John Hunter Health and Innovation Precinct (SSD-9351535)
Response to submissions

Attachment 1

Figure 2: Project Phase 2

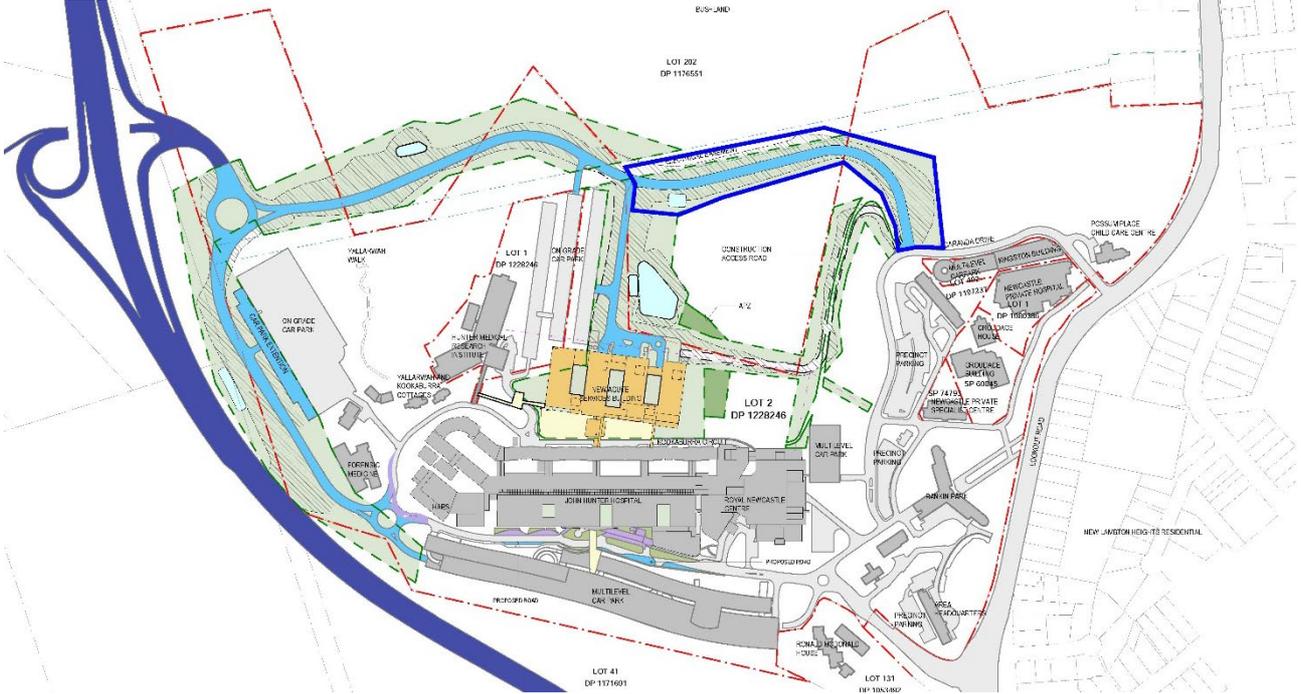
1. The Environmental Impact Statement (EIS) indicates the eastern portion of the proposed Northern Road will provide a connection to the wider hospital precinct as part of a future stage of the development (Phase 2). Confirm the target time for completion of the eastern portion of the Northern Road, identify who has responsibility for its delivery and what commitments have been made to its delivery.
